**KIRKLEES METROPOLITAN COUNCIL  
INVESTMENT & REGENERATION SERVICE**

**DELEGATED DECISION TO DETERMINE PLANNING APPLICATIONS**

Reference No:	<b>2025/62/90862/E</b>
Site Address:	Land Adj, 26, Track Lane, Batley, WF17 7AA
Description:	Erection of detached dwelling
Recommending Officer:	Emma Thompson

**DECISION – REFUSED**

A1 02/2025 11 003	Elevations as Proposed Floor Plans as Proposed
	Planning Application
	New House in Garden of Existing Track Road Batley WF17 7AA
	1:100

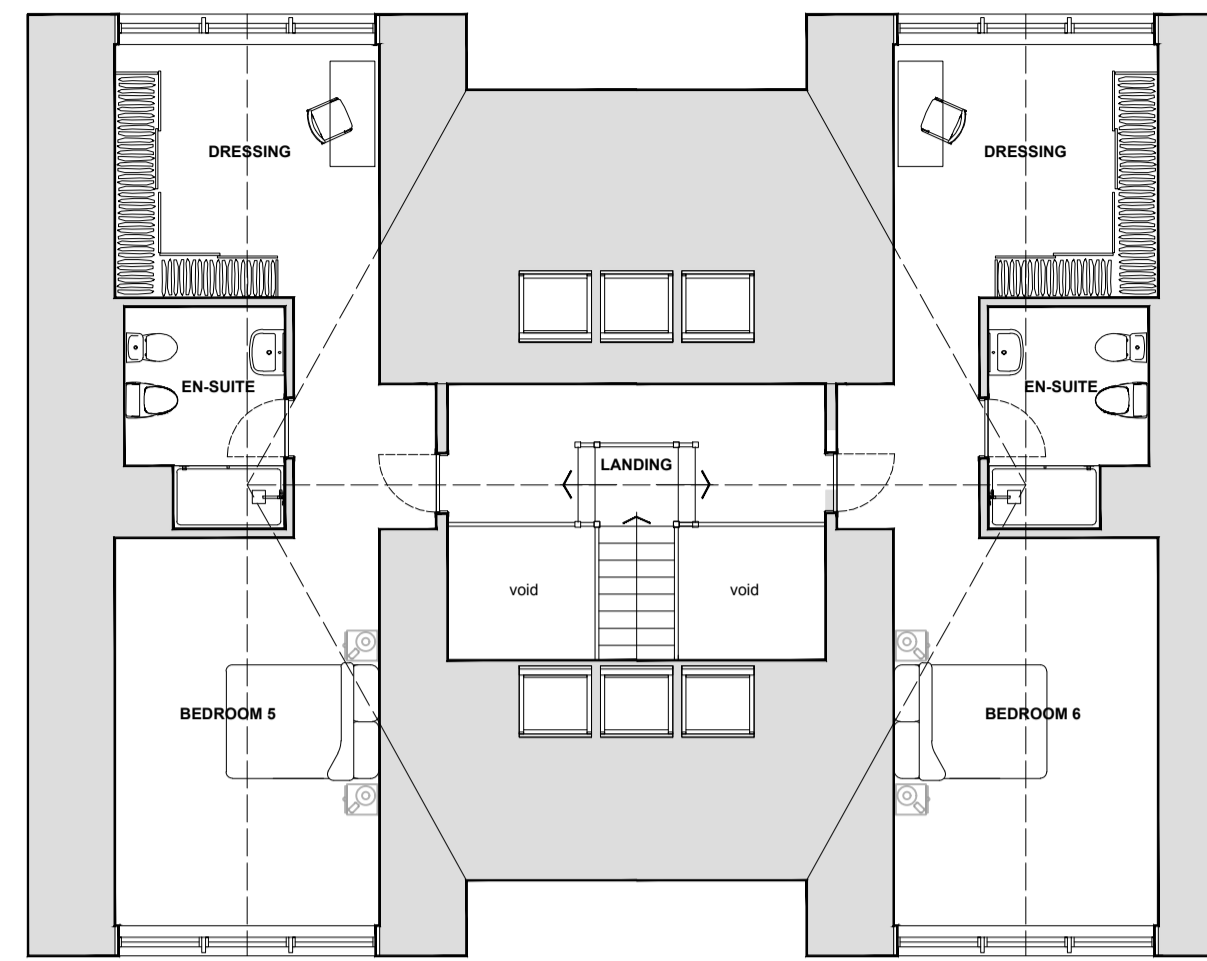
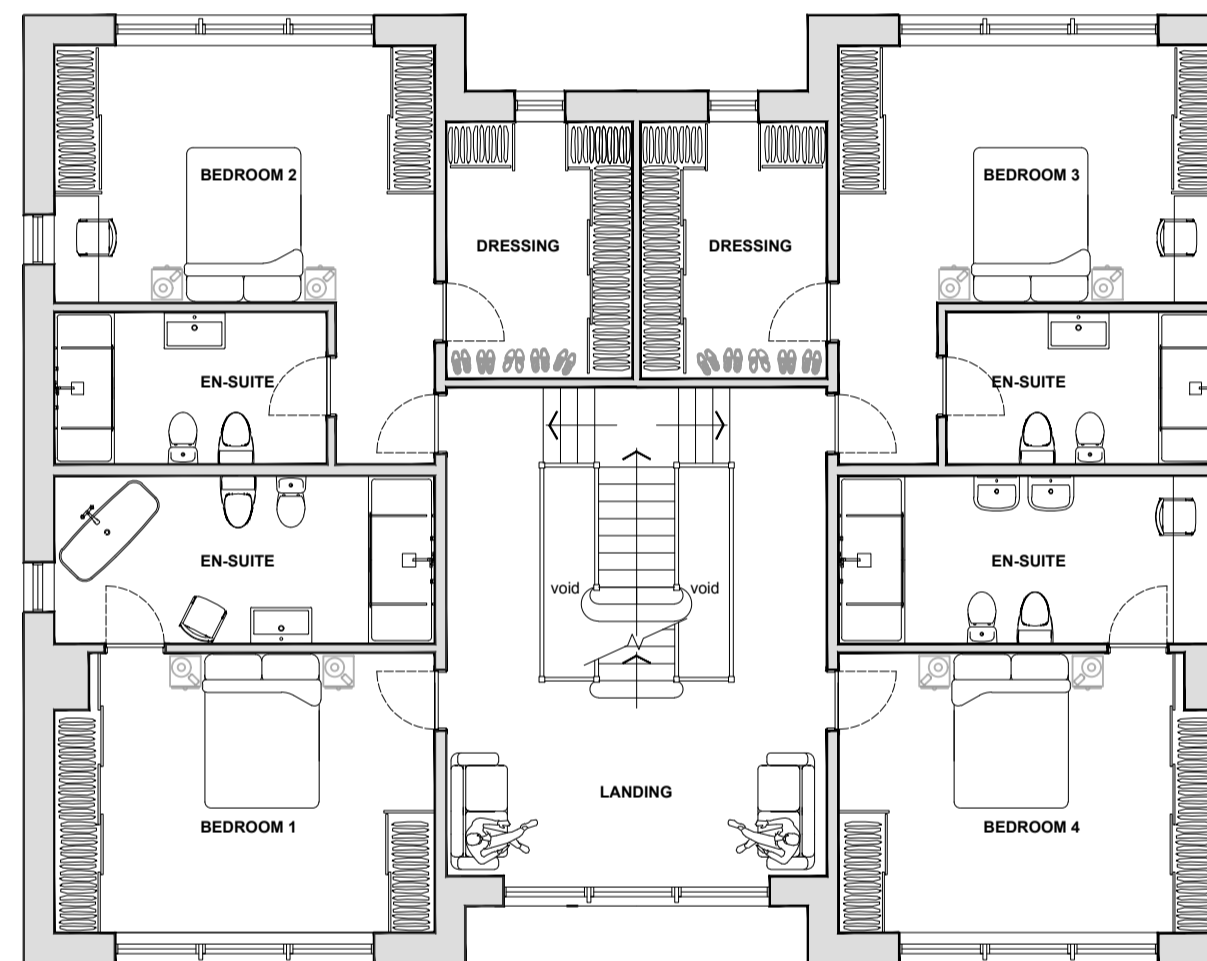
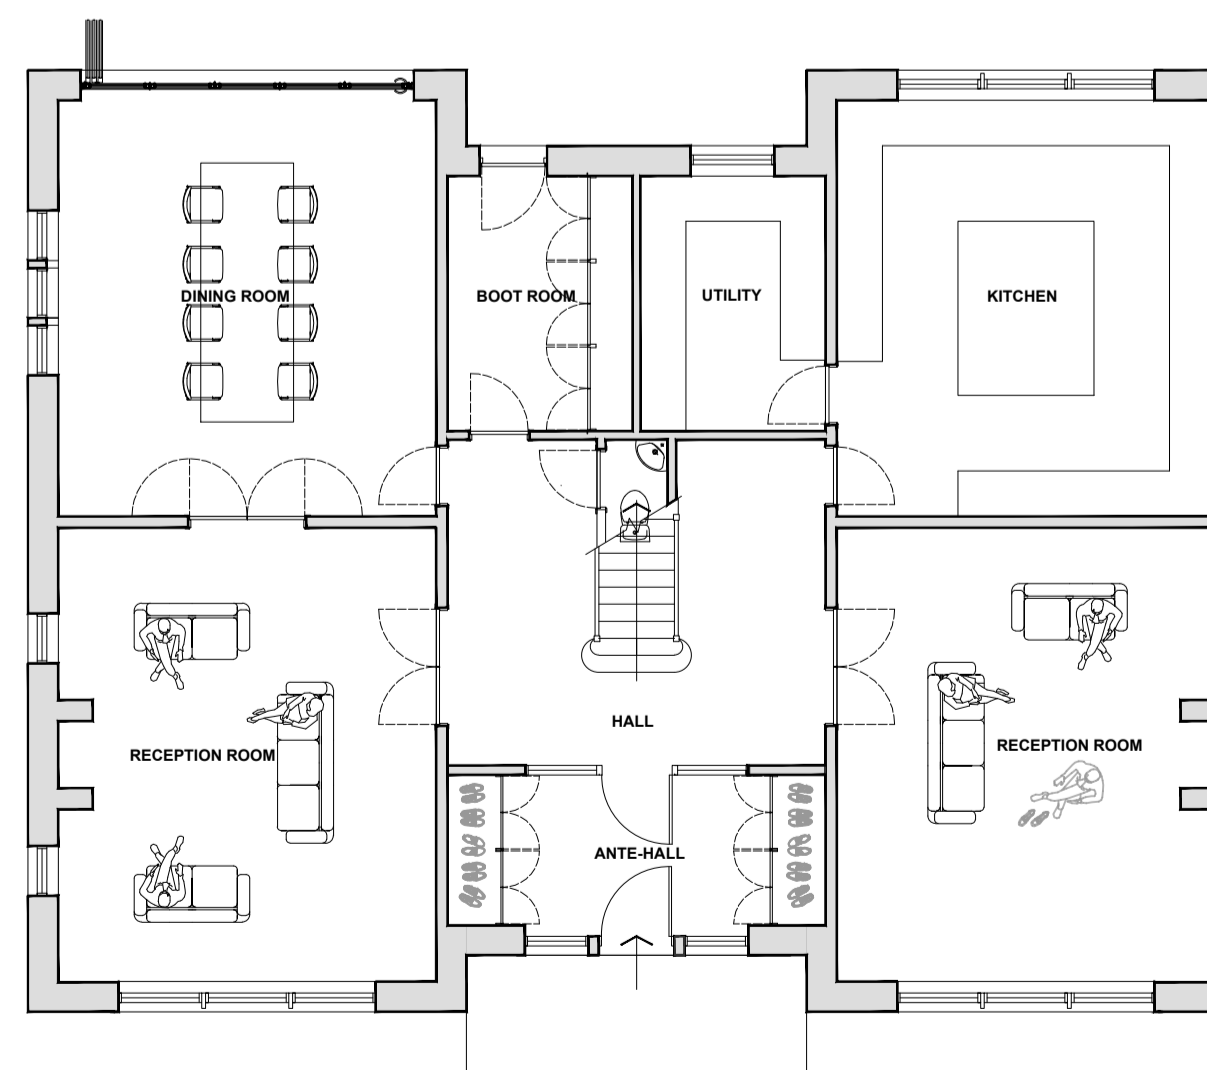
There are a mix of roof forms, within Hyrst Gardens with the adjacent property having a flat roof. The proposed dwelling would be more traditional in design compared to the existing detached dwellings on Hyrst Gardens. The two dwellings opposite have pitch roofed features which are not dissimilar from the gable end features proposed on the dwelling. Given the variety in design of the existing buildings, the proposed design is considered acceptable on balance.

The dwelling would be faced in coursed natural stone, under blue slate roofing and with aluminium framed windows which would somewhat reflect the material used in the existing buildings in Hyrst Gardens. To ensure that the dwelling would sit comfortably within the street scene, it is considered appropriate to impose a condition requiring samples of materials to be submitted, should planning permission be granted.

The application site is of a sufficient size to support a dwelling, as proposed with a parking area to the front and amenity space to the rear. The dwelling would have two storeys with rooms at second floor level utilising the roof space; this is considered acceptable as the majority of the neighbouring dwellings also have two and a half stories. In terms of footprint and massing, the proposed dwelling would not be out of keeping with the neighbouring dwellings on Hyrst Gardens. The scale is considered acceptable. However, whilst a dwelling may be acceptable, it is considered appropriate to include a condition (should planning permission be granted) removing permitted development rights for any additions to ensure the site does not become overdeveloped.

Plan Title: Tree Impact Plan

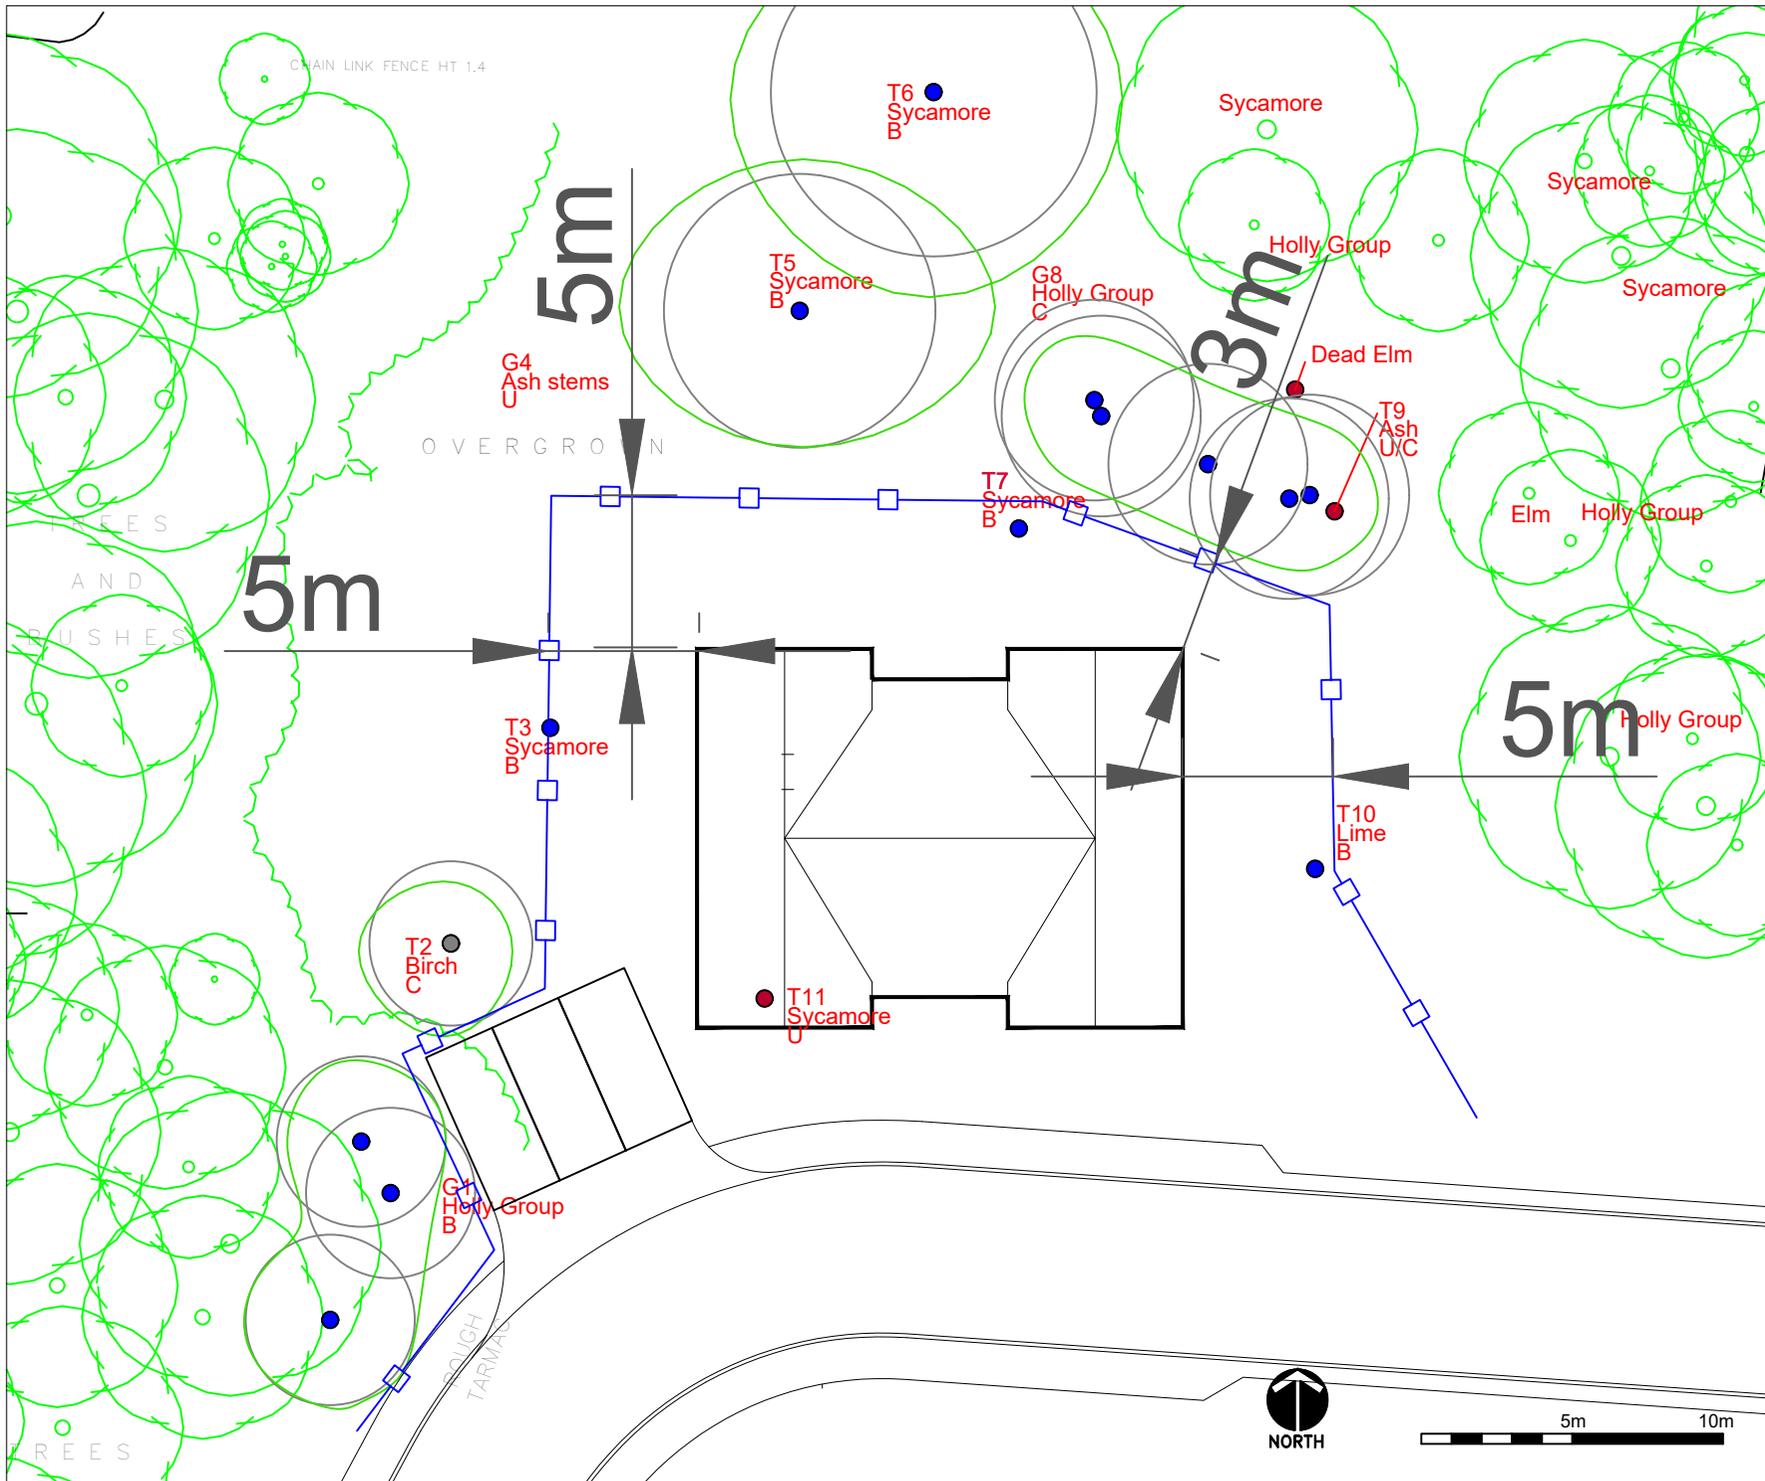
There are multiple trees subject to Tree Preservation Orders (TPO) within the red line boundary of the site. An Arboricultural Impact Assessment (AIA), Method Statement (AMS) and Tree Planting Plan have been submitted alongside the application and this has been reviewed by KC Trees. The Tree Impact Plan shows that 5 trees would be removed as part of the scheme, all of which are protected under a TPO. KC Trees object to the proposal as the scheme fails to comply with policy LP33 of the KLP which states:

The loss of TPO protected trees on this site and the long-term impact of the proposed dwelling so close to retained trees is contrary to Policies LP24 and LP33 of the Kirklees Local Plan.

In addition to the loss of trees the proposal would require the significant pruning of existing trees, and would lead to a continued pressure for the pruning or total removal of these trees in response to the resultant impact they would have upon the occupiers of the dwelling in terms of leaf drop and overshadowing.
